## Development Facilitation Team (DFT) – Review Comments

Project No: PR-2020-003443 Date: 02/07/2024

### Application For: SD-2024-00017 – PRELIMINARY/FINAL PLAT

**FIERRO & COMPANY** agent for **HOLLY PARTNERS, LLC** requests the aforementioned action(s) for all or a portion of: **LOTS 5 & 6, UNSER MCMAHON CENTER** zoned **MX-M**, located on **UNSER BLVD NW** between **MCMAHON BLVD NW** and **BANDELIER DR NW** containing approximately **1.903** acre(s). **(A-11)**

LOT LINE ADJUSTMENT PLAT OF  
 LOTS 5-A AND 6-A  
 UNSER AND MCMAHON CENTER  
 WITHIN THE TOWN OF ALAMEDA GRANT  
 PROJECTED SECTION 2, TOWNSHIP 11 NORTH, RANGE 2 EAST, N.M.P.M.  
 CITY OF ALBUQUERQUE  
 BERNALILLO COUNTY, NEW MEXICO  
 JANUARY 2024

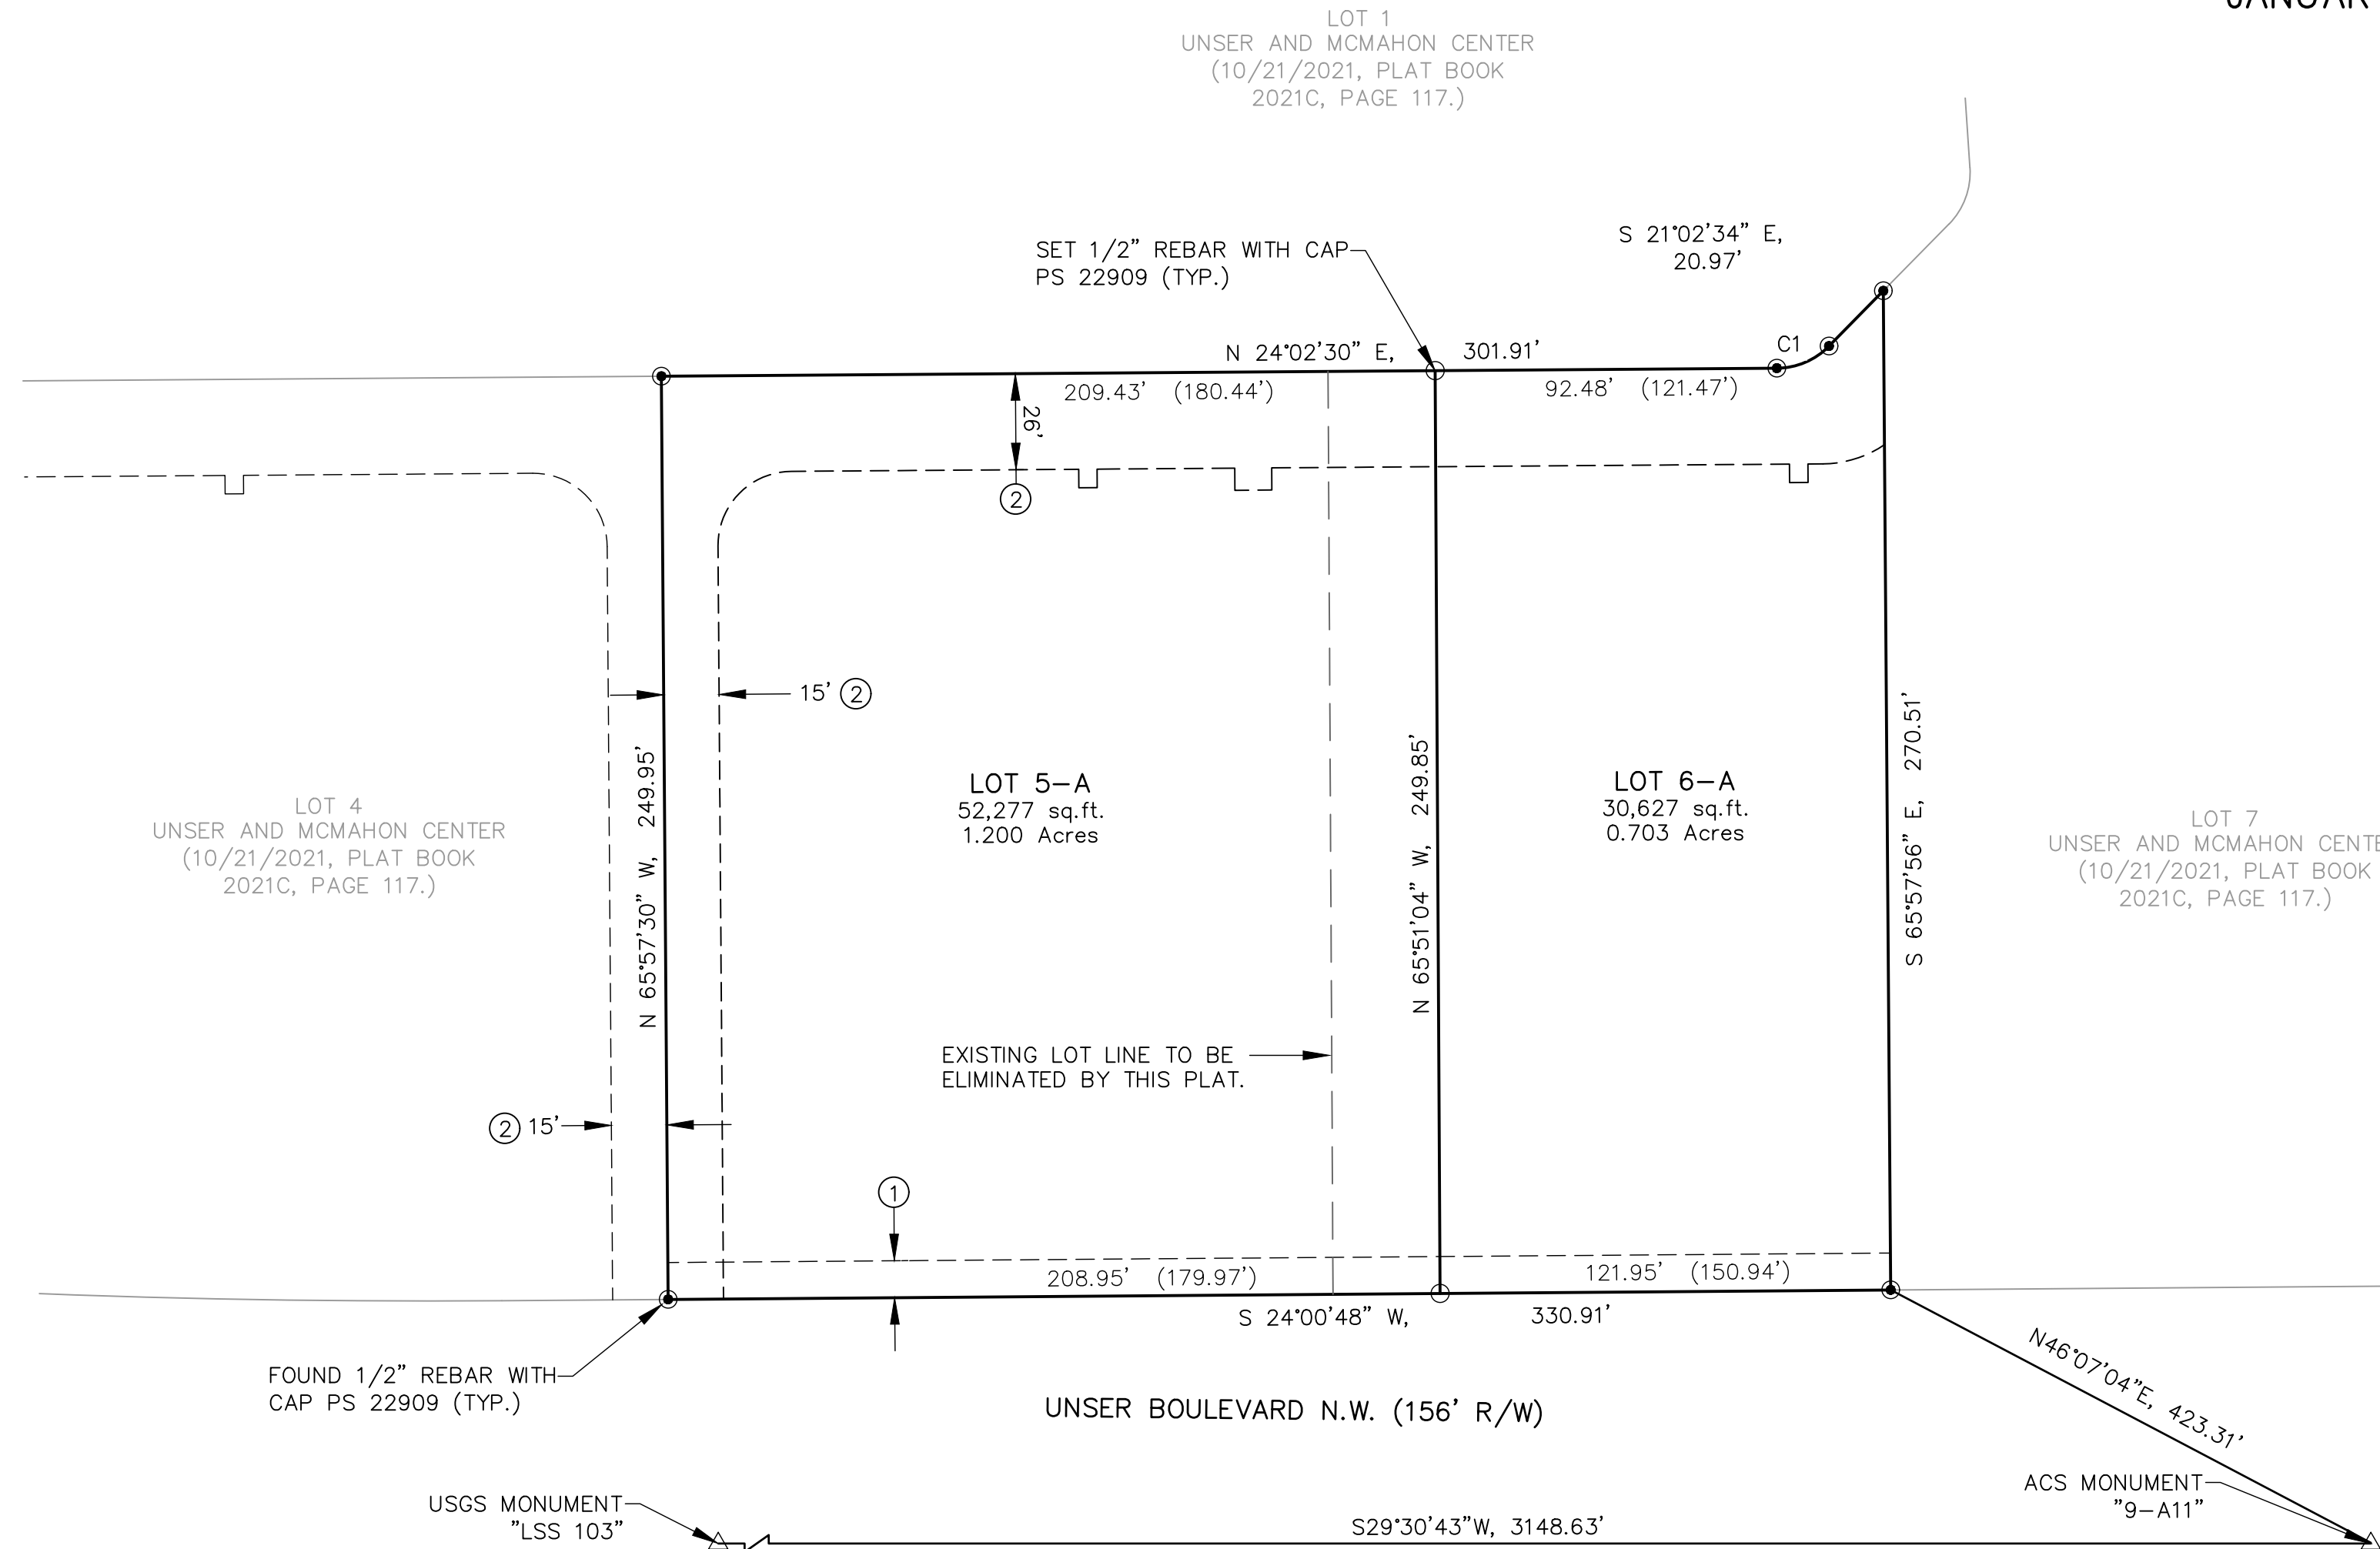
1. Code Enforcement has no comments and no objections to the proposed lot line removal.
2. The property is zoned MX-L in our AGIS system, but MX-M on the submittal. Please confirm correct zone prior to submittal.

- The application numbers must be added to the Plat. Final platting documents must be sealed and signed by a design professional licensed in the State of New Mexico.
- If infrastructure is needed, an IL-Infrastructure list, and/or IIA-Infrastructure Improvements Agreement with financial guarantee will be required.
- Prior to final sign-off of the plat, the AGIS office must approve the DXF file and proof of approval must be provided.
